Memorandum

To:	Linda Pineau	Date:	January 6, 2023
From:	April Ng		
Project:	Butenwieser/Wiley Residence 6838 96 th Ave SE Mercer Island, WA 98040 King County APN 302405-9010	File No:	2205-199
Subject:	Building Permit Review SUB2 Response

The comments are restated below, followed by responses. Updated drawings have been clouded with Revision 2: 1/6/23 Building Permit Resubmittal.

DRAINAGE PLAN

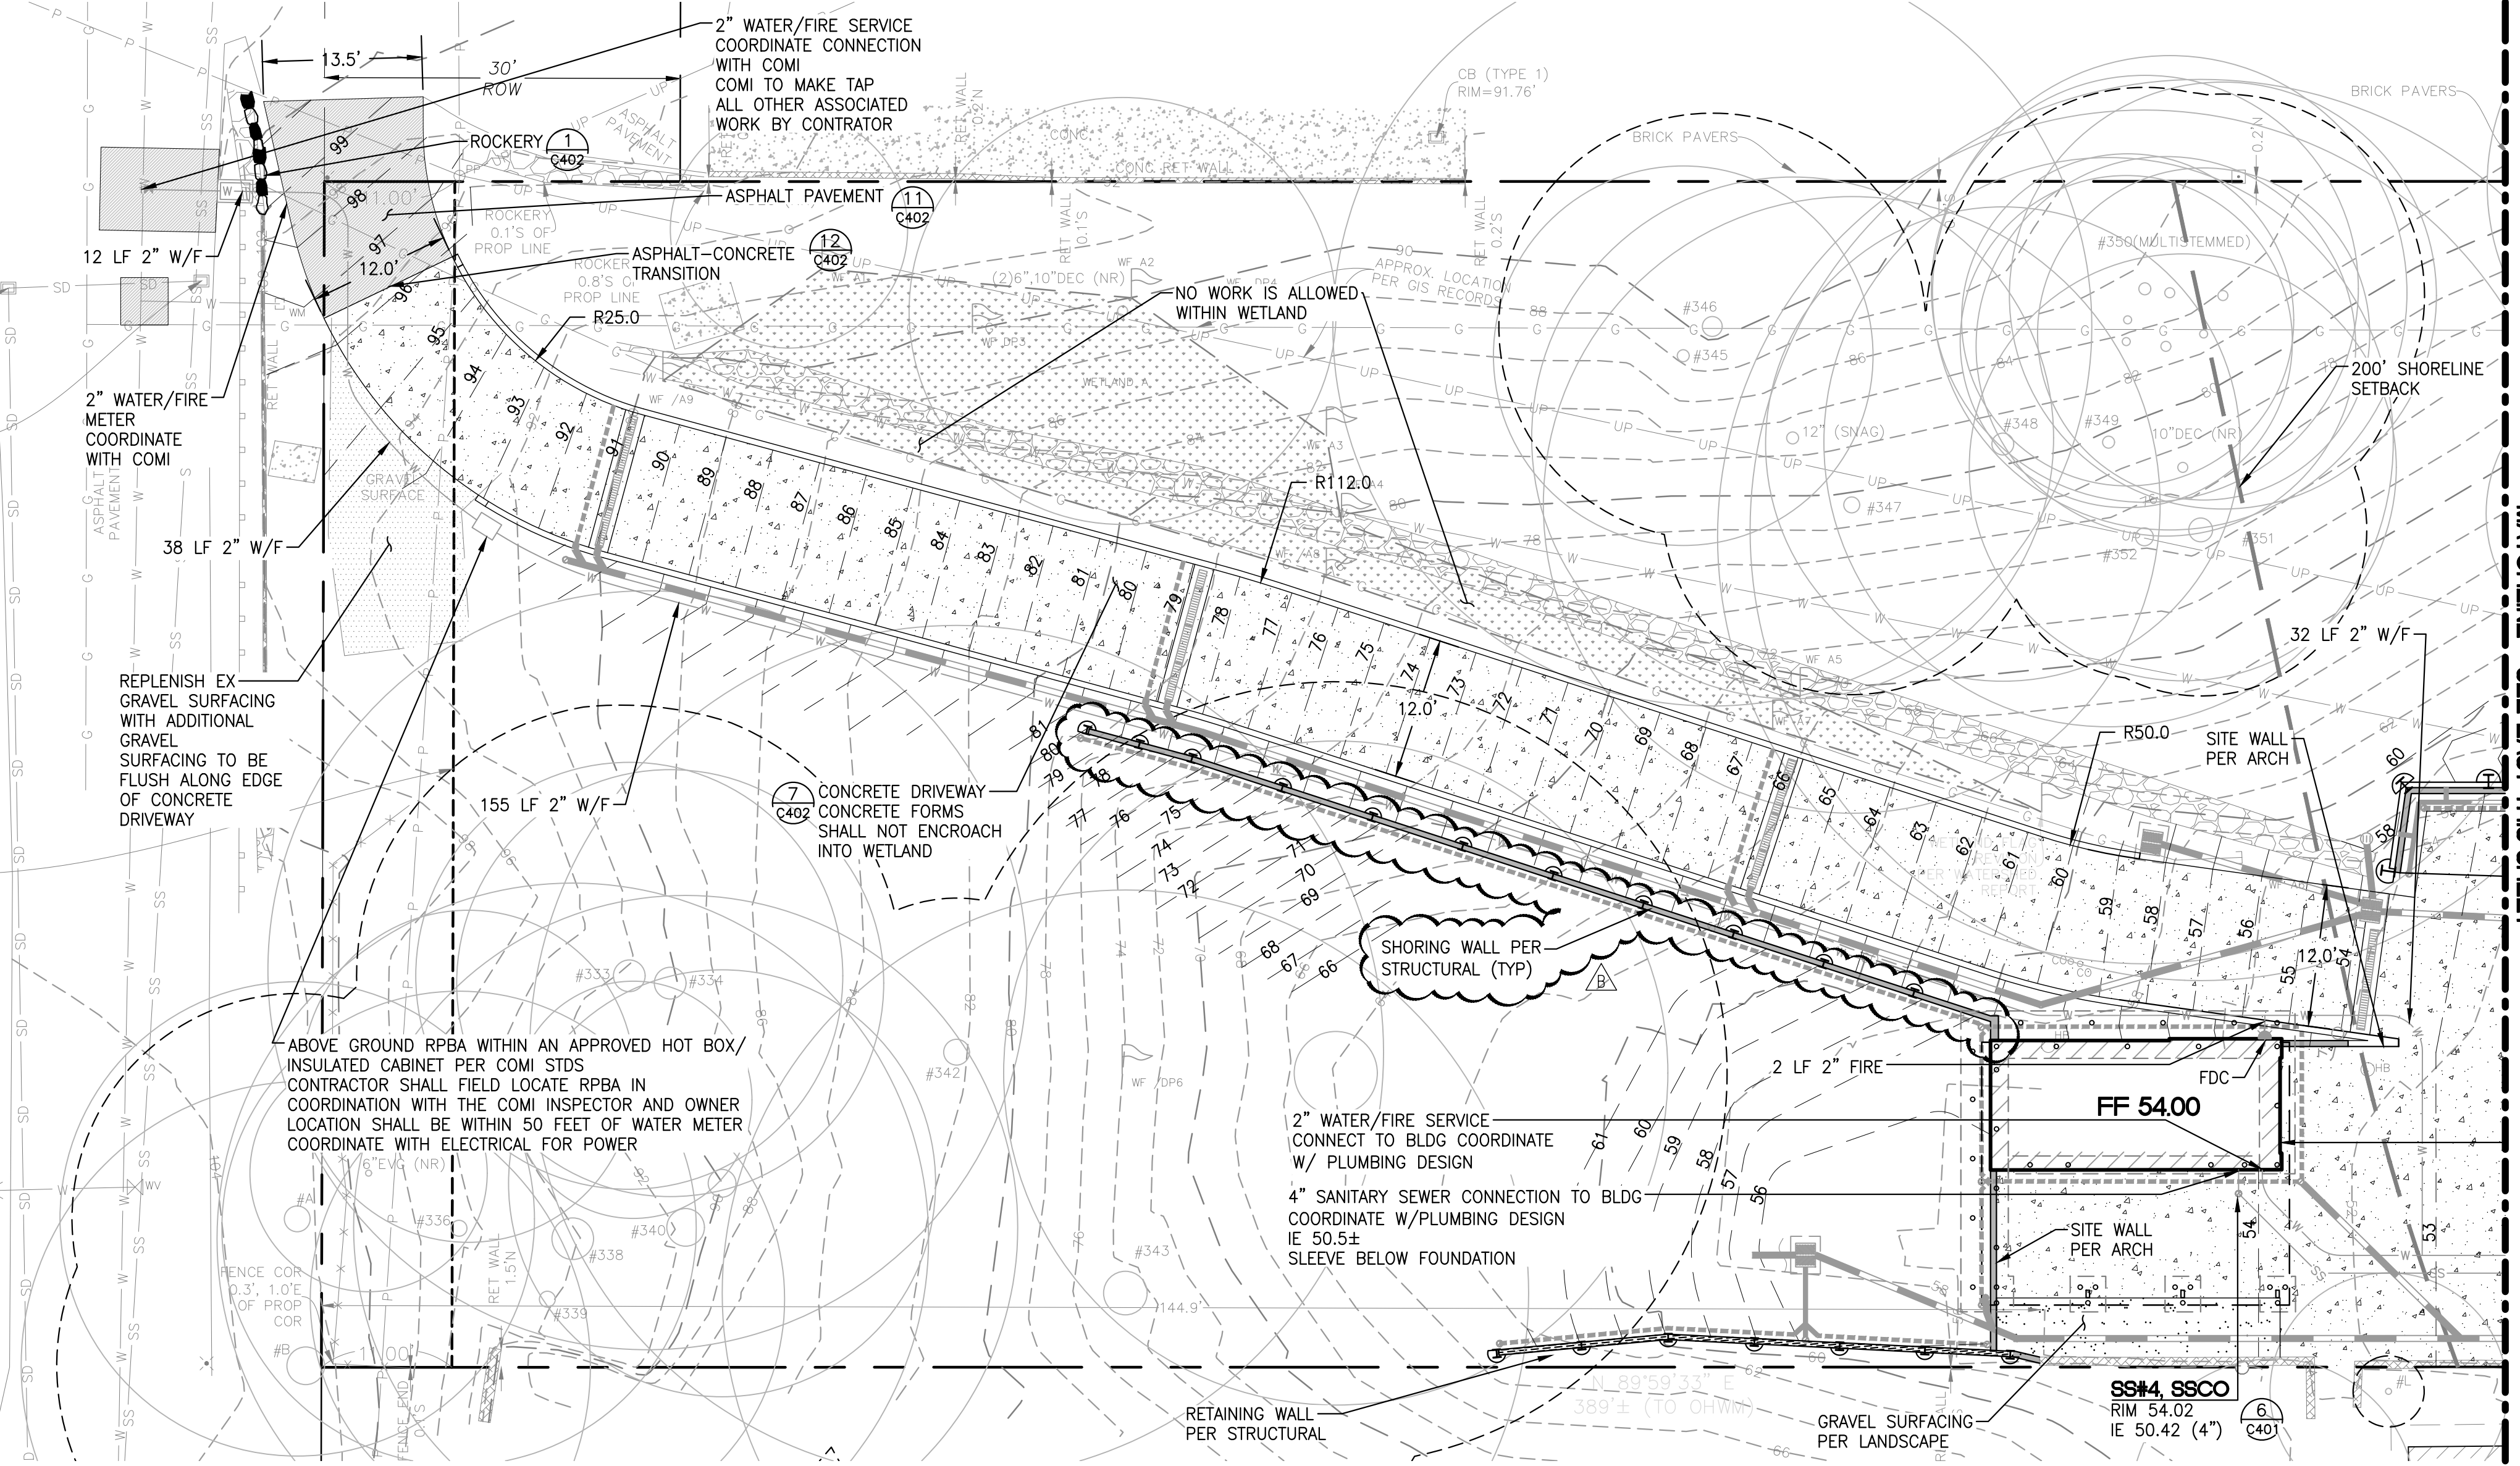
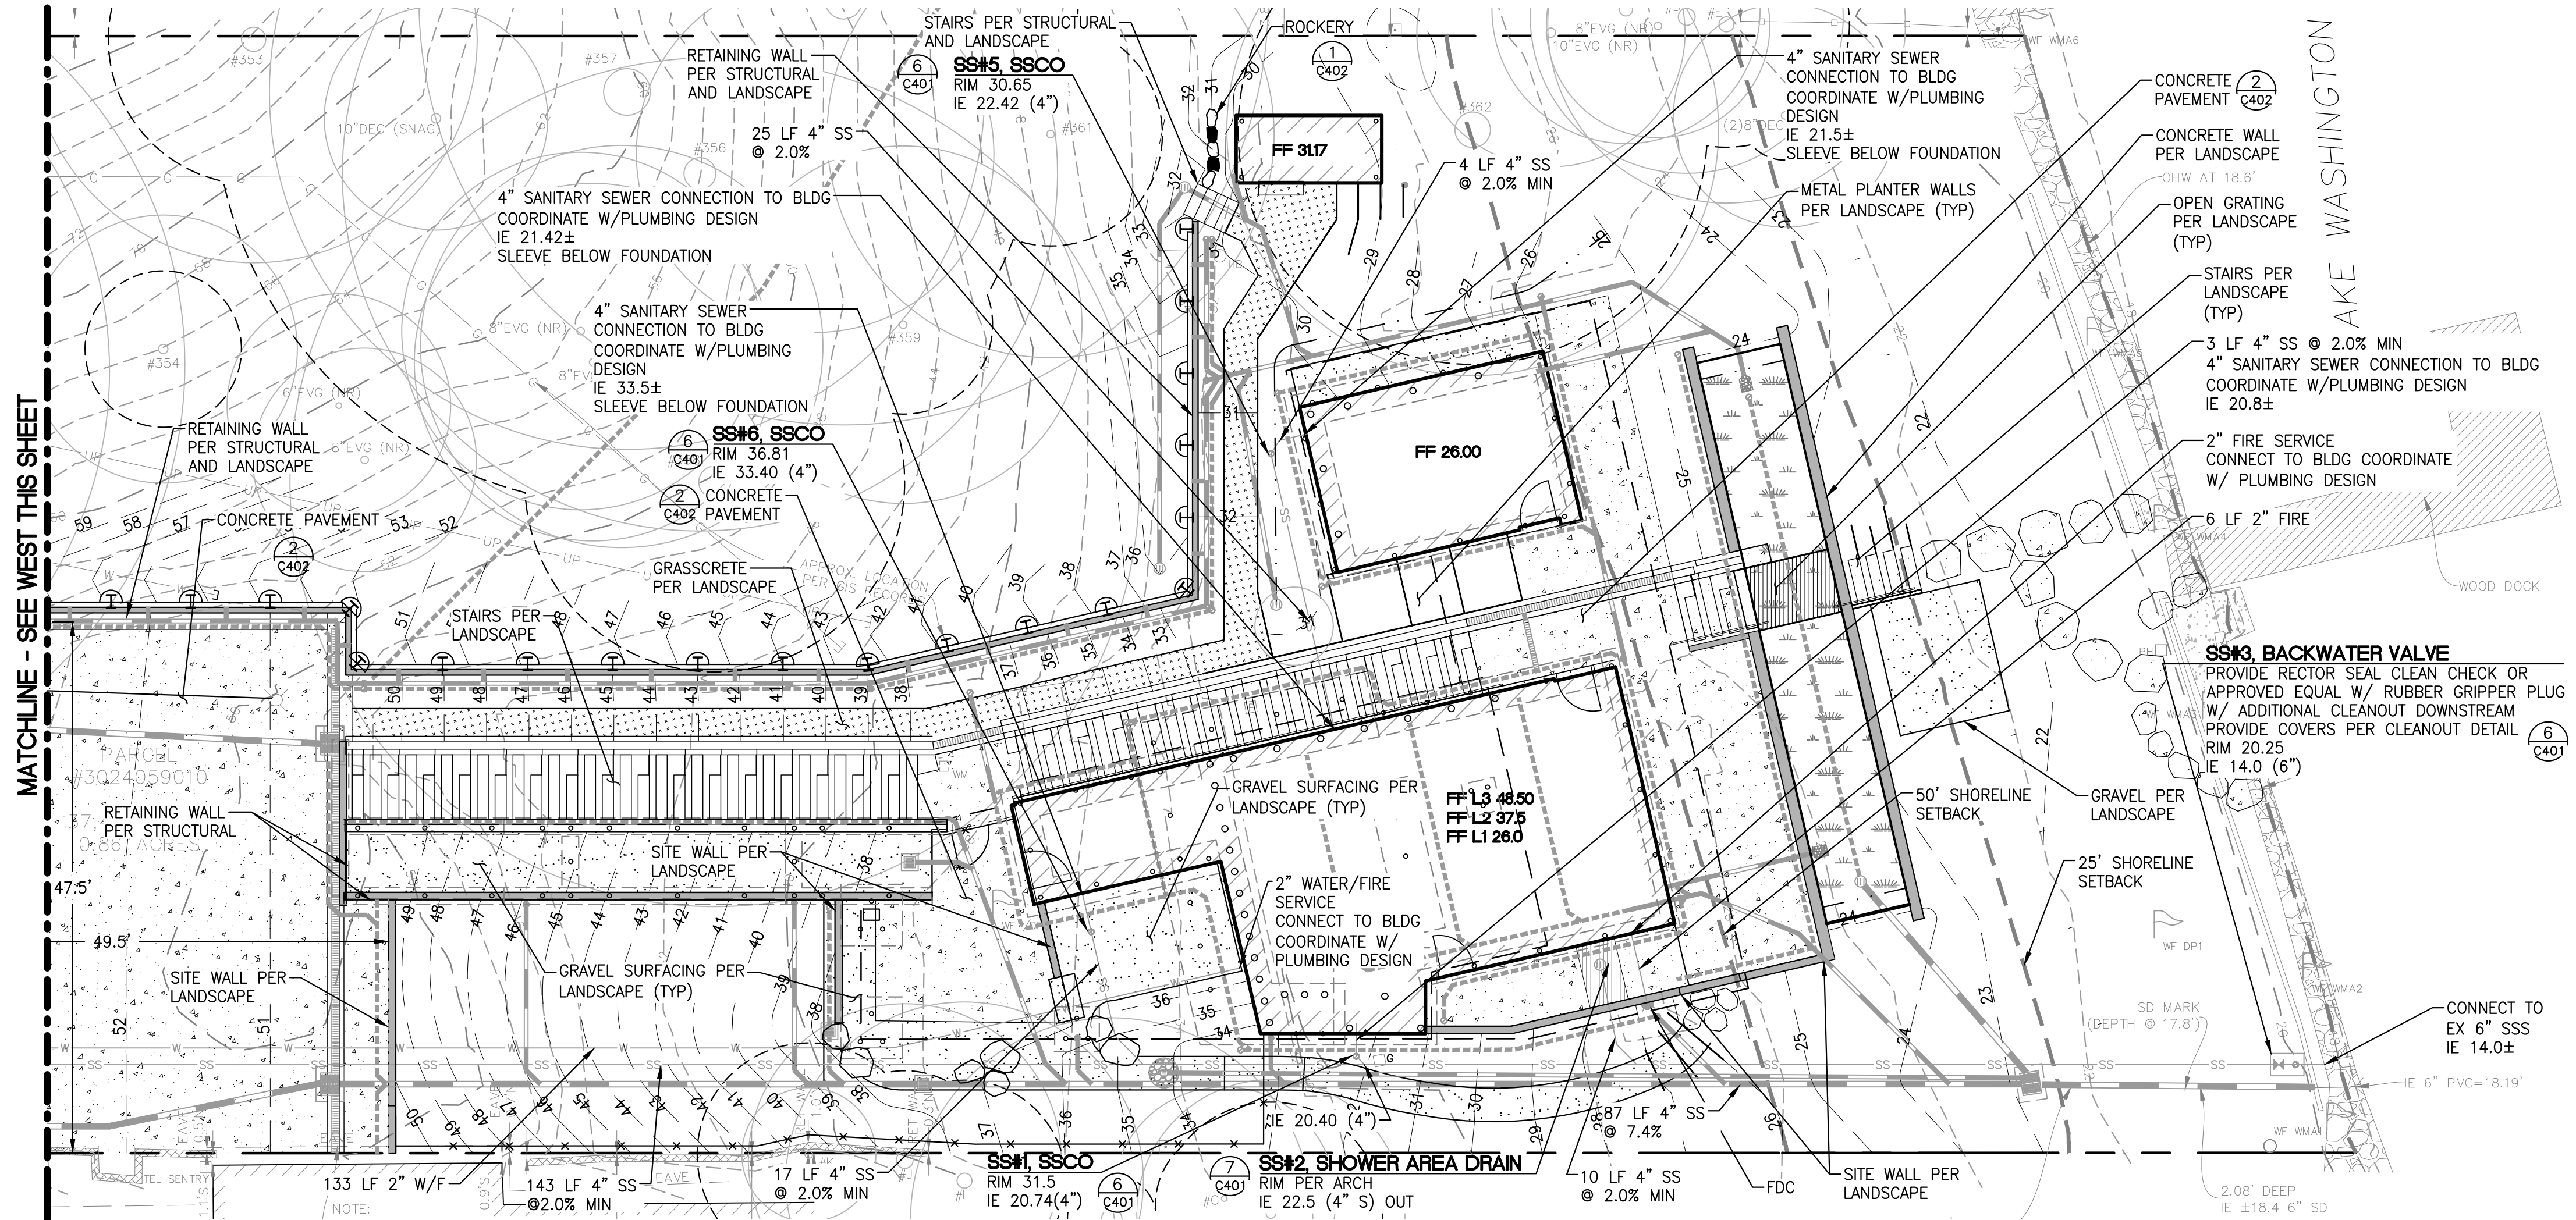
Engineering Review		
<i>Comment</i>	<i>Response</i>	<i>Document Ref.</i>
C100 You cannot discharge the construction runoffs to the sewer line.	Construction stormwater meeting the DOE allowable discharge requirements will be routed to the 6-inch storm drain to Lake Washington.	C100
C200 Please provide legend for this new asphalt to clarify what is new, what is existing.	New vs. existing asphalt has been hatched such that it is clear what will be new. This has been shown on the project legend.	C200A, C200B
C200 Is this represent new asphalt or existing asphalt.	New vs. existing asphalt has been hatched such that it is clear what will be new. This has been shown on the project legend.	C200A, C200B
C200 Please a note to say that the existing storm pipe will need to be video inspected prior to make connections, repair or replacement will be required per the direction of the project civil engineer.	Video inspection note has been added to the plans.	C200B

UTILITIES & PAVING PLAN
C300

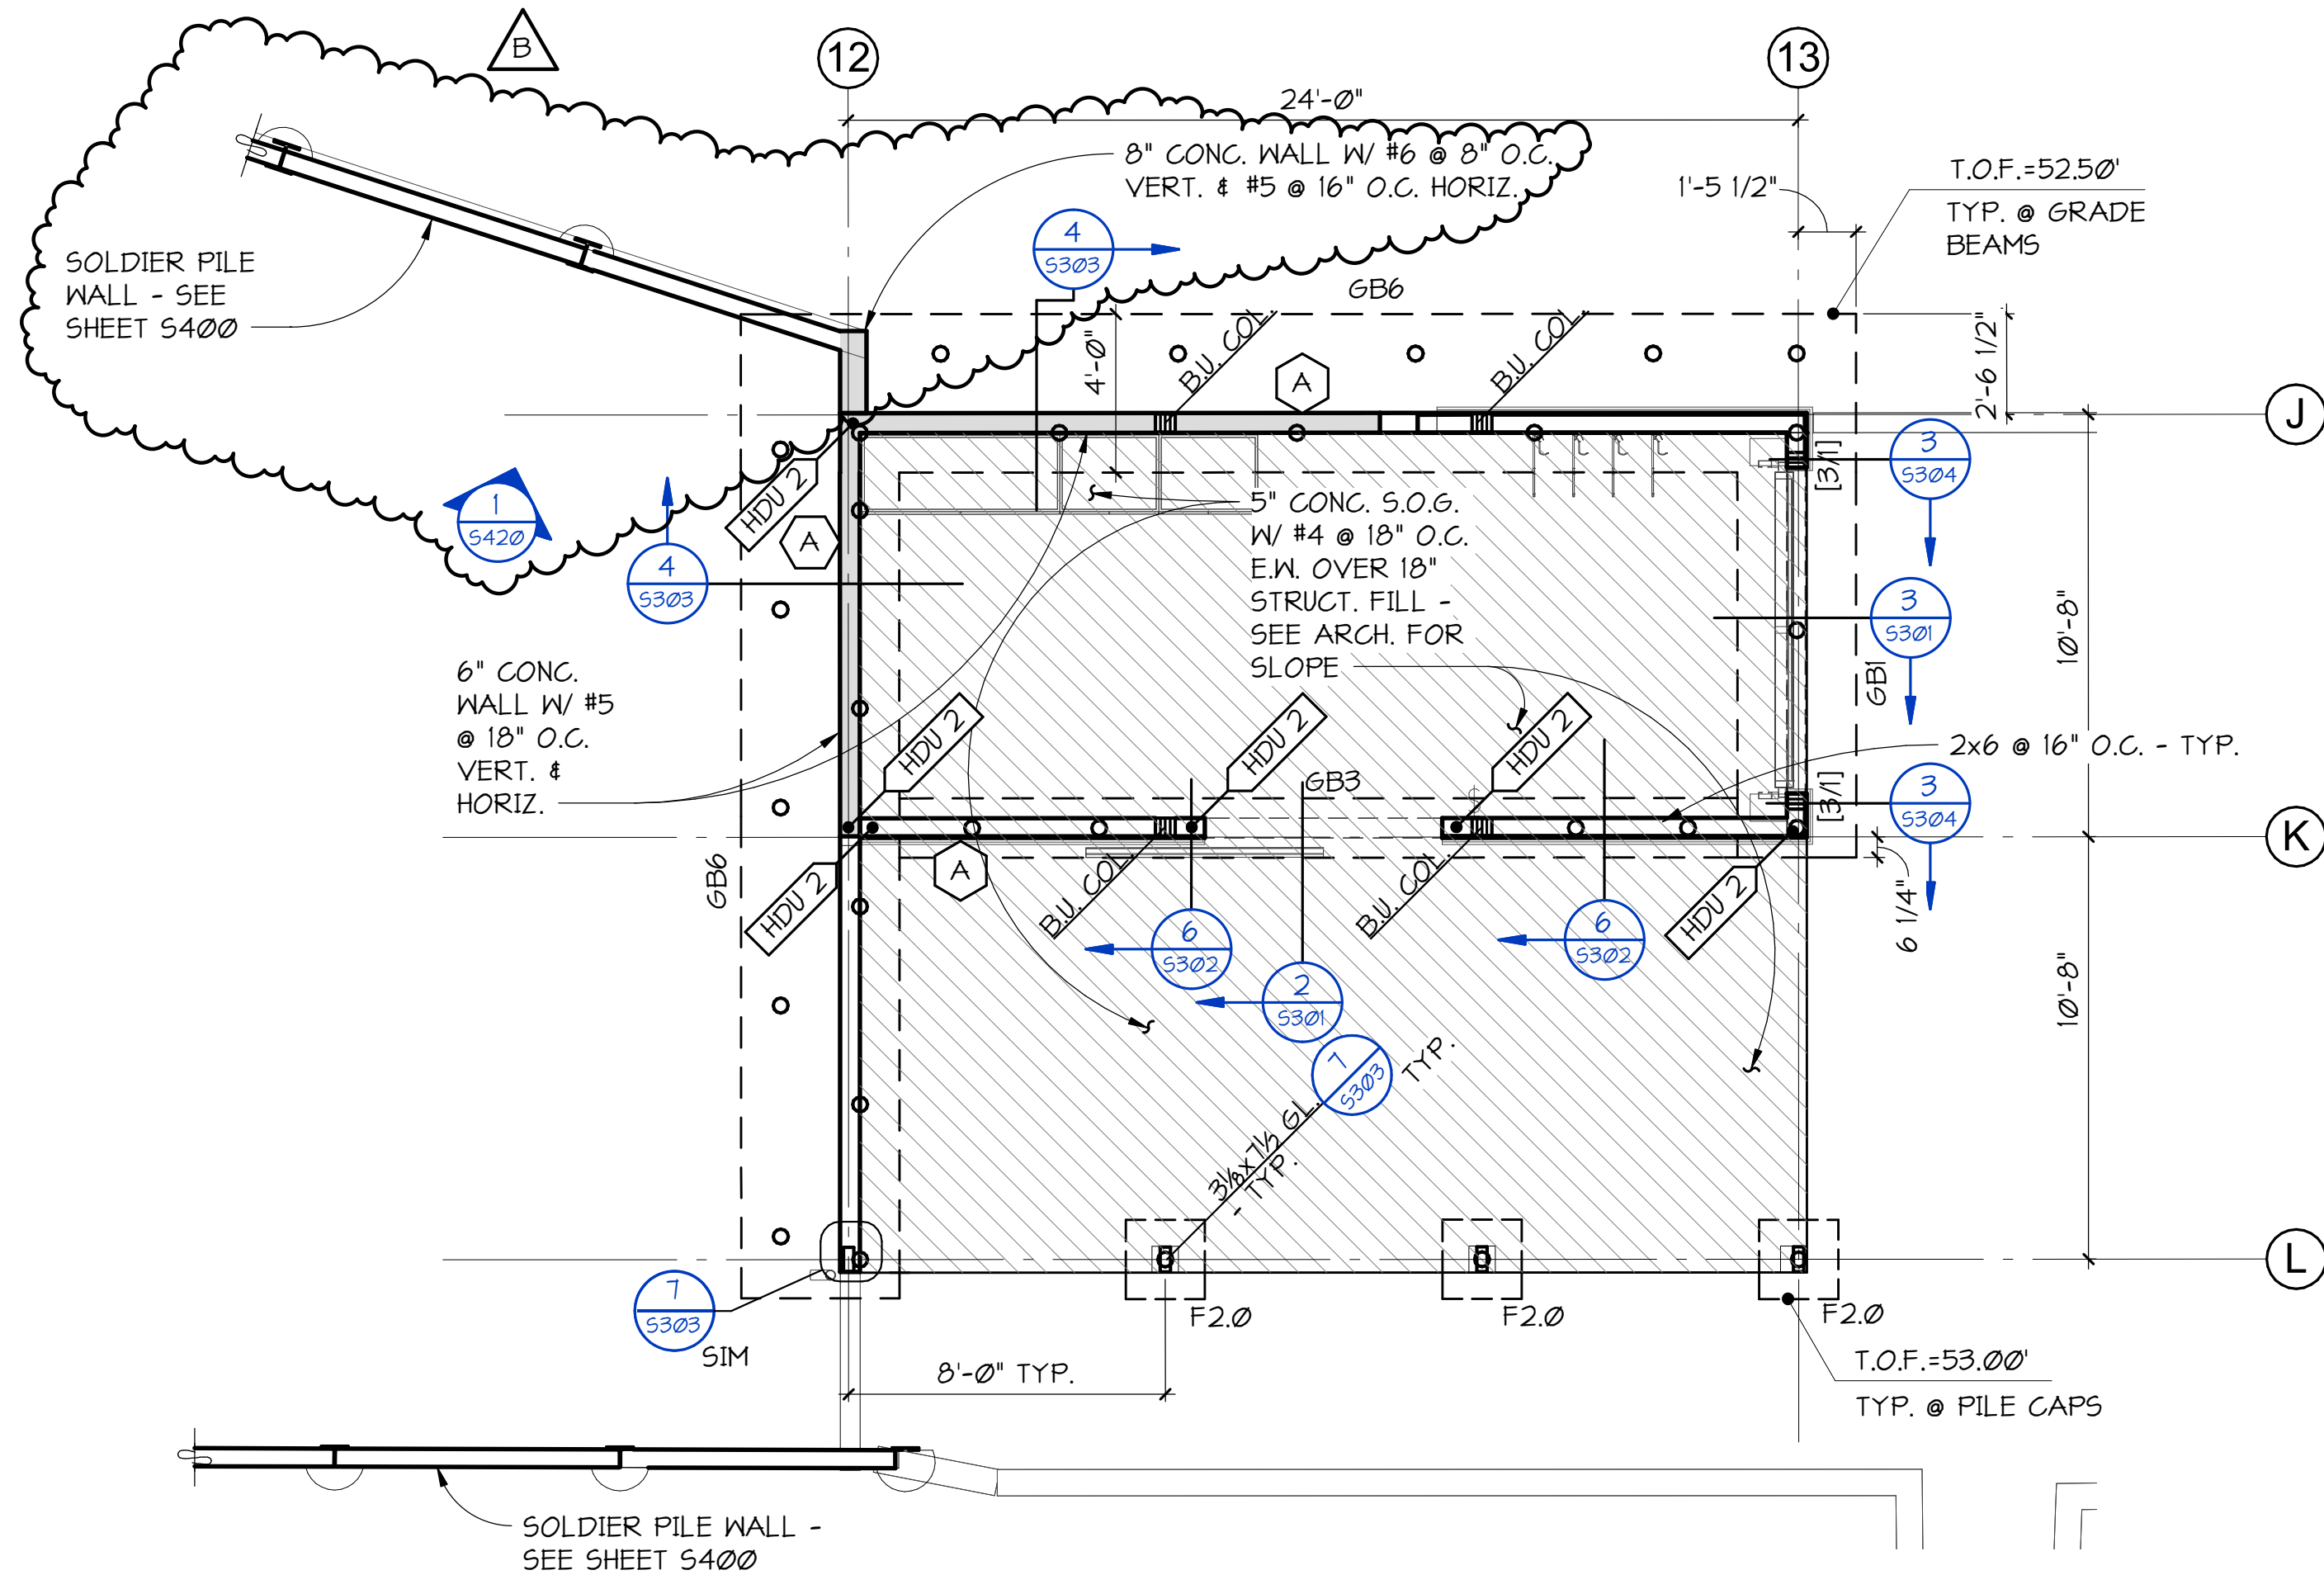
C300 The new water meter shall be located between the edge of the pavement and the guard rail, approximate 18' from the edge of pavement, 18" from the gas line at this location.	Per coordination with Ruji at City of Mercer Island. Location of the meter shall be revised plan and not moved within the limits of the existing concrete retaining wall.	C300
